Phone: 0300 123 6780
Email: developeras@lancashire.gov.uk
Your ref: 3/2026/0468
Our ref: 3/2026/0468/HDC/KW
Date: 04 August 2026

Location: Healings Farm West Bradford Road Waddington BB7 3JE
Proposal: Proposed erection of a two-storey self-build dwelling and associated annexe following demolition of existing workshop buildings
Grid Ref: 373537 444037

Summary

Drawing No. GA_15

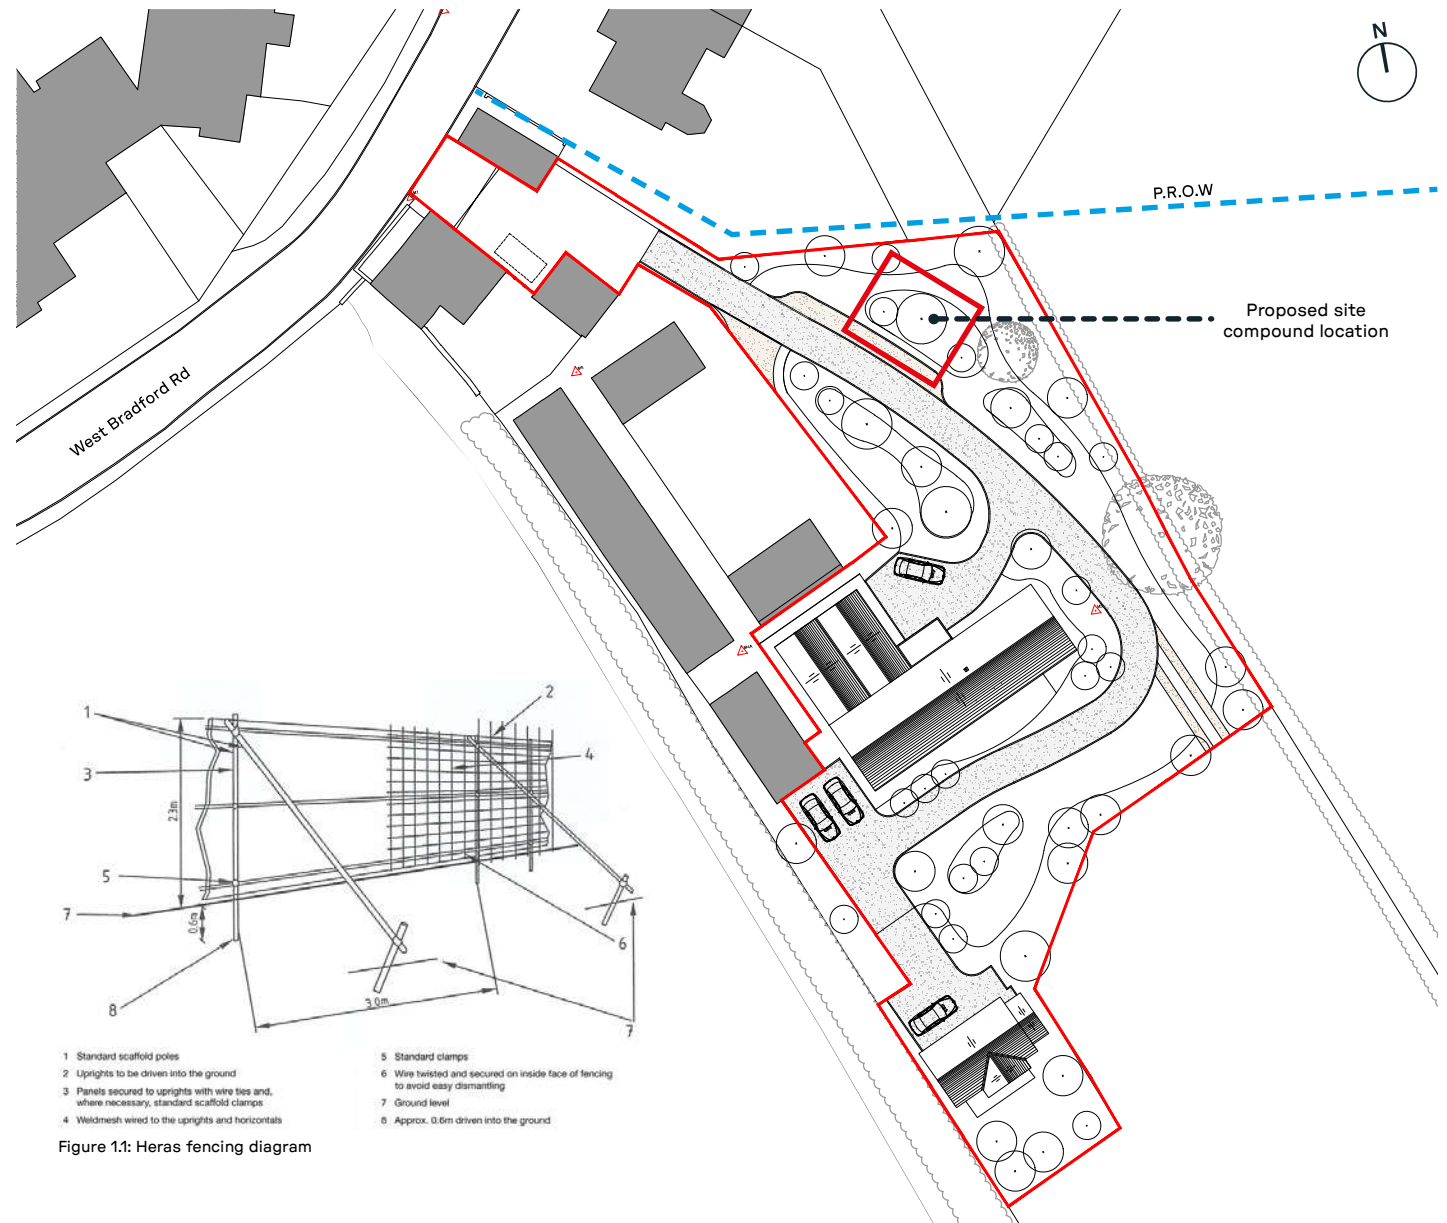
A construction management plan has also been submitted and is considered acceptable for the proposal however, 24 hour contact details should be provided prior to commencement and as the site is located close to Waddington and West Bradford CE Primary School, deliveries by HGV's should take place outside of school peak travel time.

1. The construction of the development shall be carried out in accordance with the Construction management plan. Reason: In the interests of the safe operation of the adopted highway during the demolition and construction phases.

Drawing No. GA_07

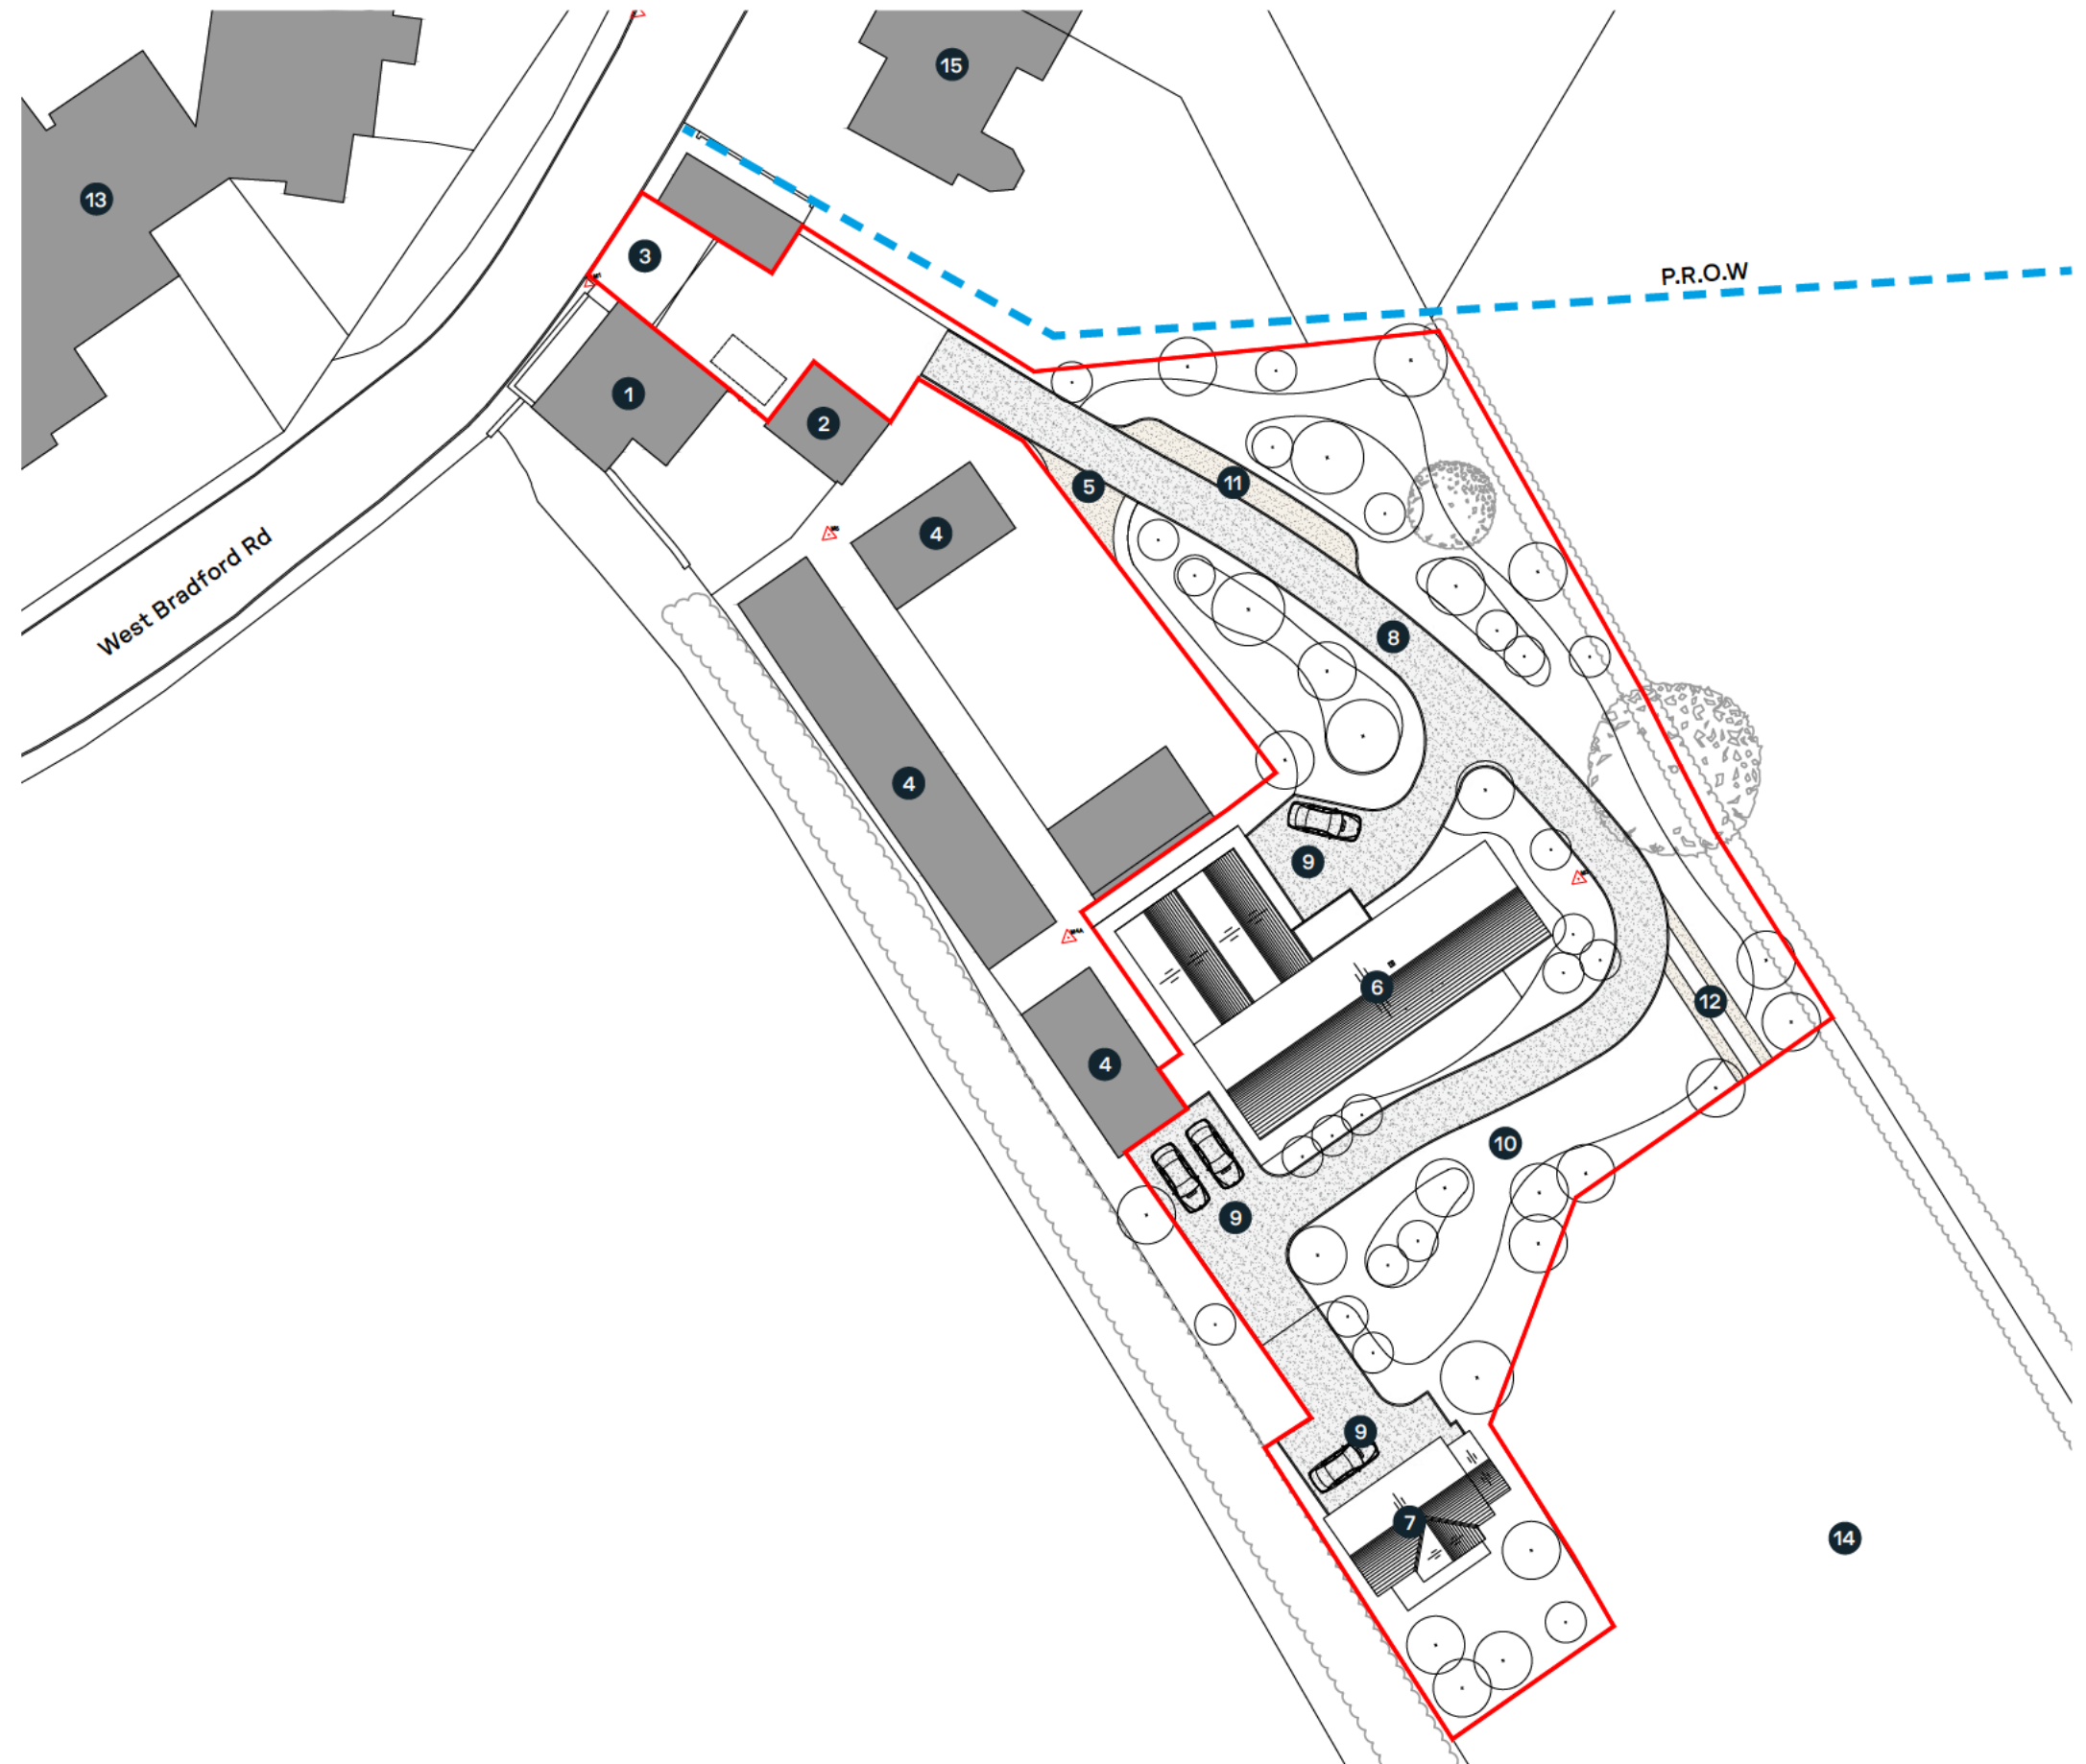
The LHA have reviewed drawing number GA_07 titled "Site Plan As Proposed" and are aware that a minimum of 3 car parking spaces will be provided within the site which complies with the parking guidance as defined within the Joint Lancashire Structure Plan. The drawing also shows the internal track will be approximately 3.5m wide and is supported by a passing place.

3. No part of the development hereby permitted shall be occupied until such time as the access and access track arrangements shown on Rural Solutions drawing number GA_07 have been implemented in full. Reason: To ensure that vehicles entering and leaving the site may pass each other clear of the highway, in a slow and controlled manner, in the interests of general highway safety and in accordance with the National Planning Policy Framework.
